KITTITAS COUNTY
DEPARTMENT OF PUBLIC WORKS
Paul D. Bennett, P.E., Director

MEMORANDUM

TO: Jan Sharar, Staff Planner, Community Development Services
FROM: Joseph Sheridan, Development Review Technician *JS*
THRU: Paul D. Bennett, P.E., Director of Public Works
DATE: October 5, 2004
SUBJECT: Buck Short Plat

N 89°05'23"W
2639.75'
SP 2004-
PART OF THE SW1/4 NW1/4, NW1/4 SW1/4,
SEC. 1 - T.19N. - R.14E., W.M.
KITITAS COUNTY, WASHINGTON

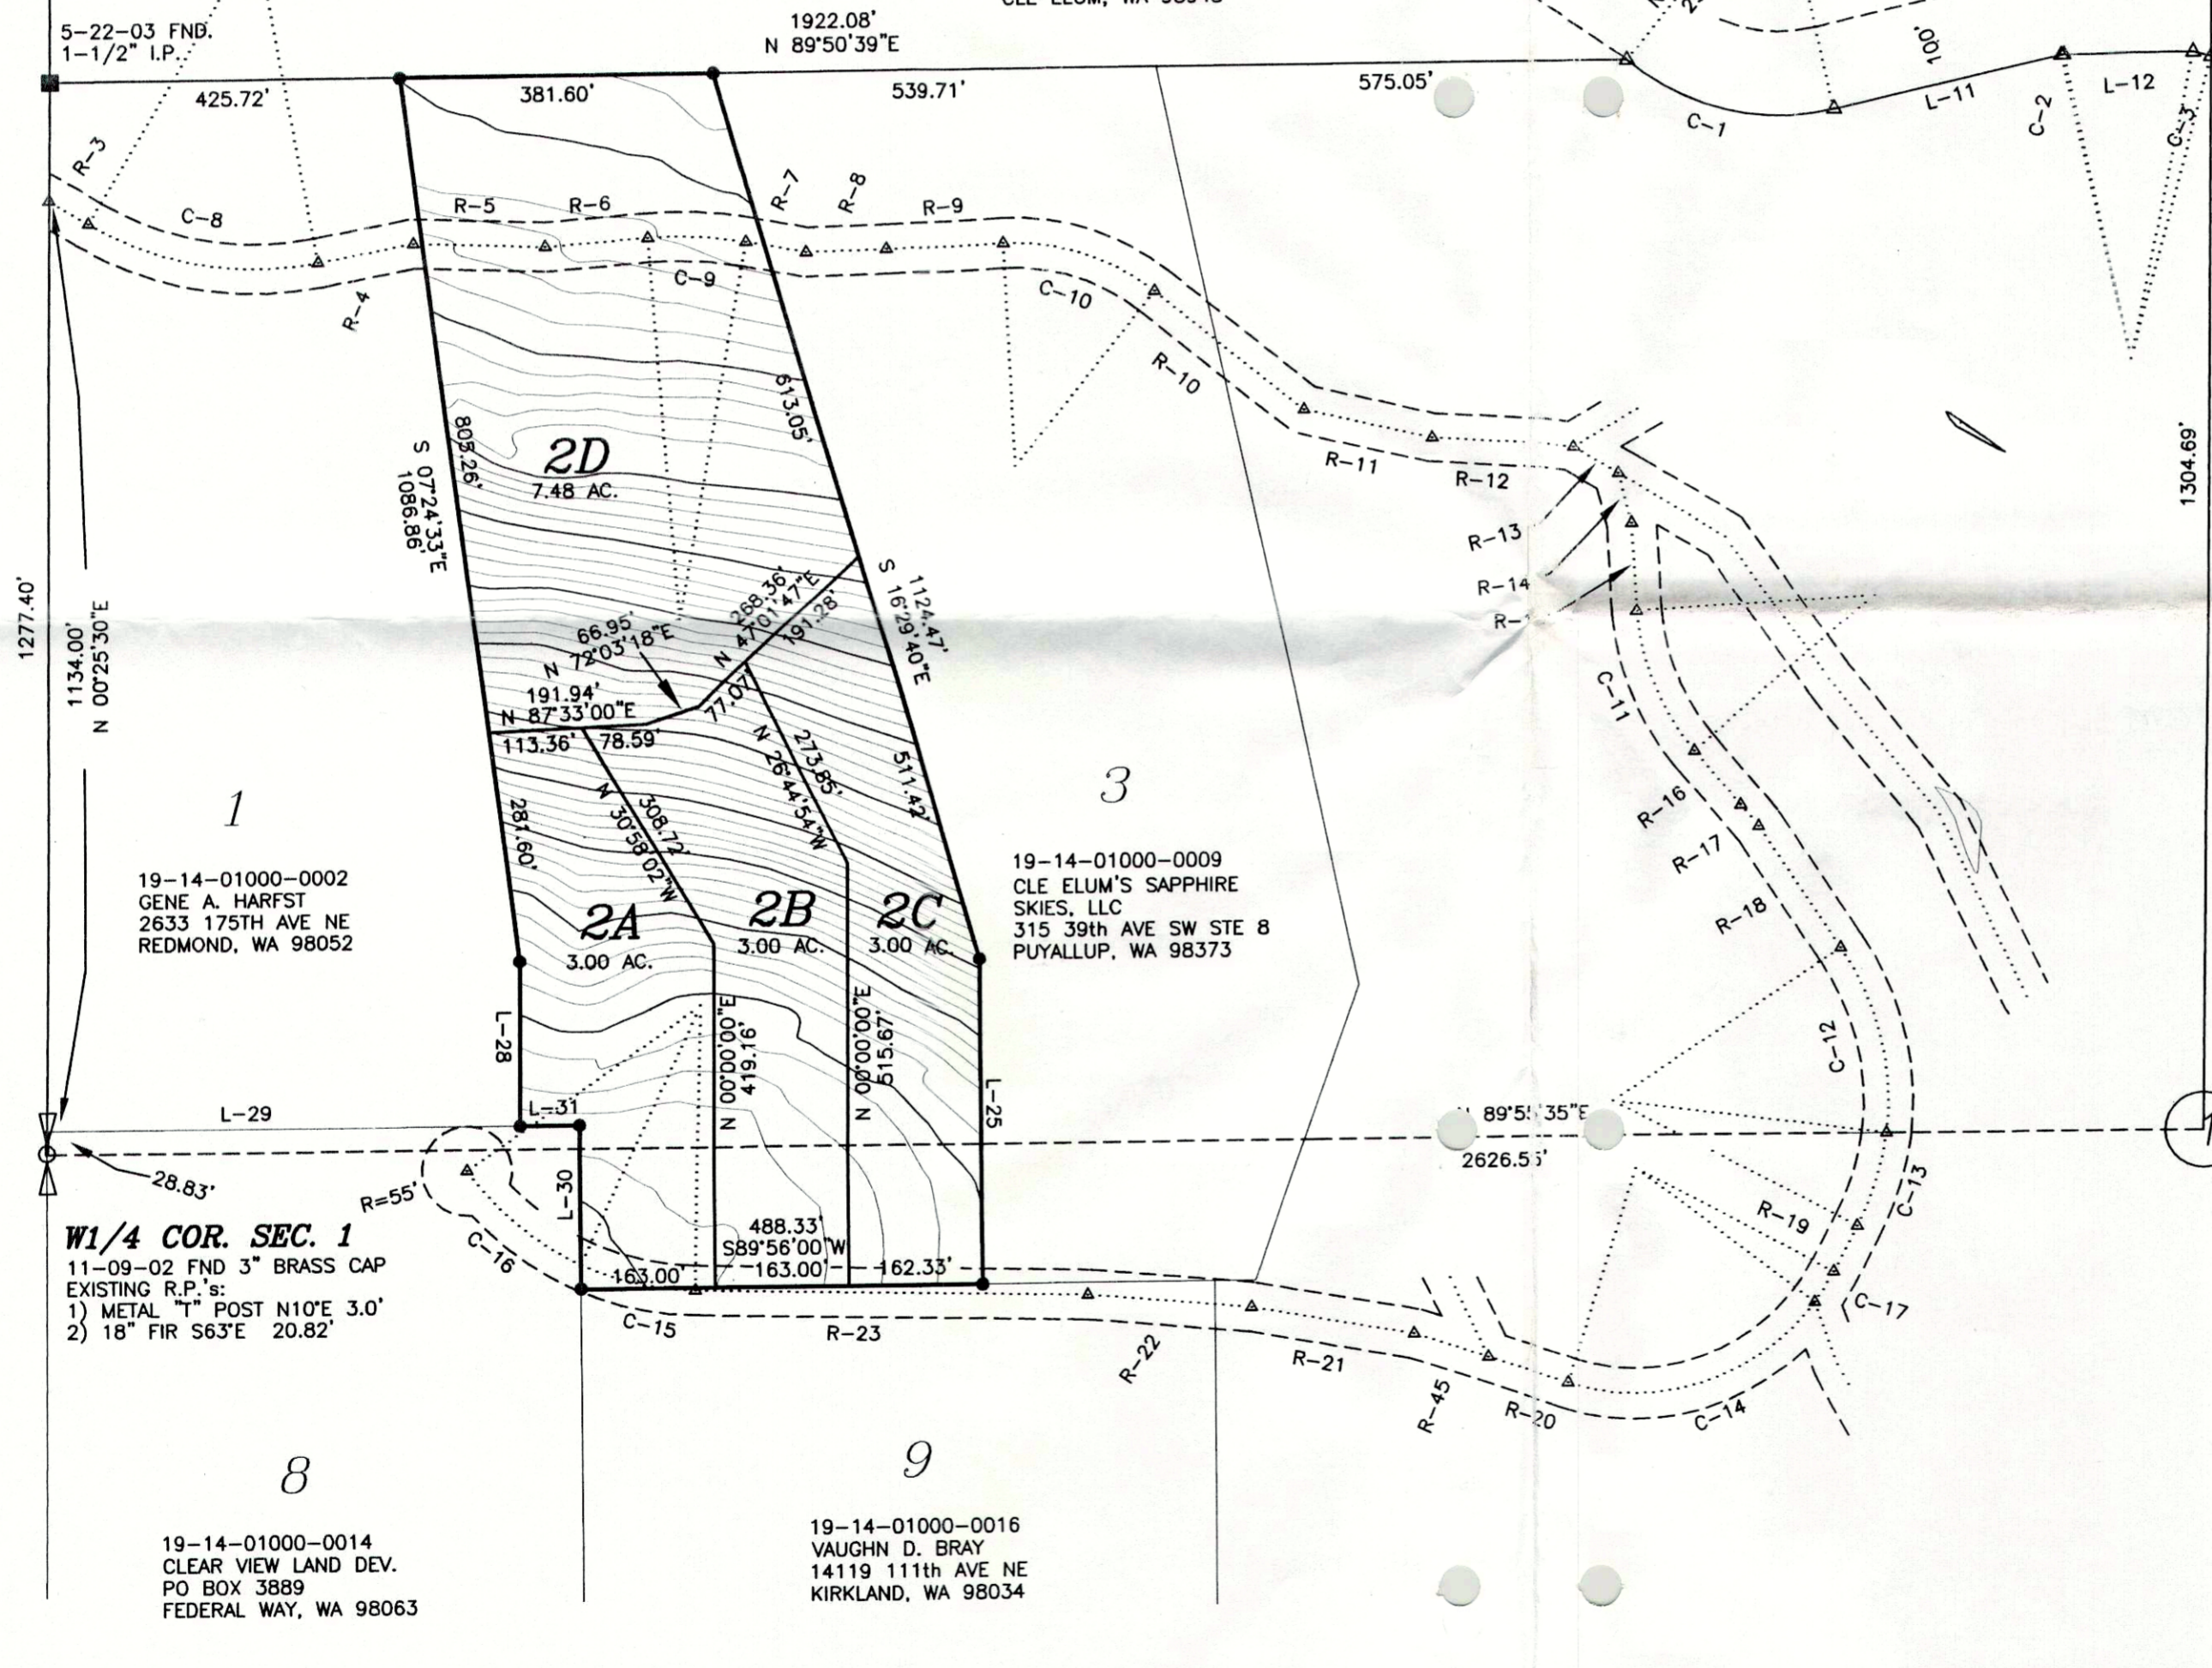
1. Access: Access shall be constructed as Low Density Private Roads and serve 3 – 40+ parcels as long as the average parcel size remains 5.01 and greater. When the average parcel size falls under the 5.01-acre minimum, High Density Private Road Standards will be triggered. All parcels being served by access road/roads shall be considered in determining this 5.01-acre minimum. (See current Kittitas County Road Standards)
 - a. Access Easements shall be improved to 60'. The roadway width shall be 20', with 1' shoulders = 22' total width.
 - b. Minimum centerline radius will be 60'.
 - c. Surface requirement 6" minimum gravel surface.

- d. Maximum Grade, 12%.
- e. Stopping Site Distance, reference AASHTO.
- f. Entering Site Distance, reference AASHTO.
- g. Maintenance of driveway approaches shall be the responsibility of the owner whose property they serve. The County will not maintain accesses.

- a. Stone Ridge, a private road, shall be improved to the standards outlined in requirement #1 above, from/including the intersection of Westside Road/Stone Ridge through to the point at which all proposed parcels are accessed.
- b. Whisper Creek, a private road, shall be improved to the standards outlined in requirement #1 above, from/including the intersection of Whisper Creek/Stone Ridge through to the point at which all proposed parcels are accessed, i.e., improved through to the point Lot 2A is accessed.
- c. Any other applicable private road(s) serving this Short Plat shall meet or be improved to Low Density (40+) Private Road Standards outlined in Table 12-1 the Kittitas County Road Standards.
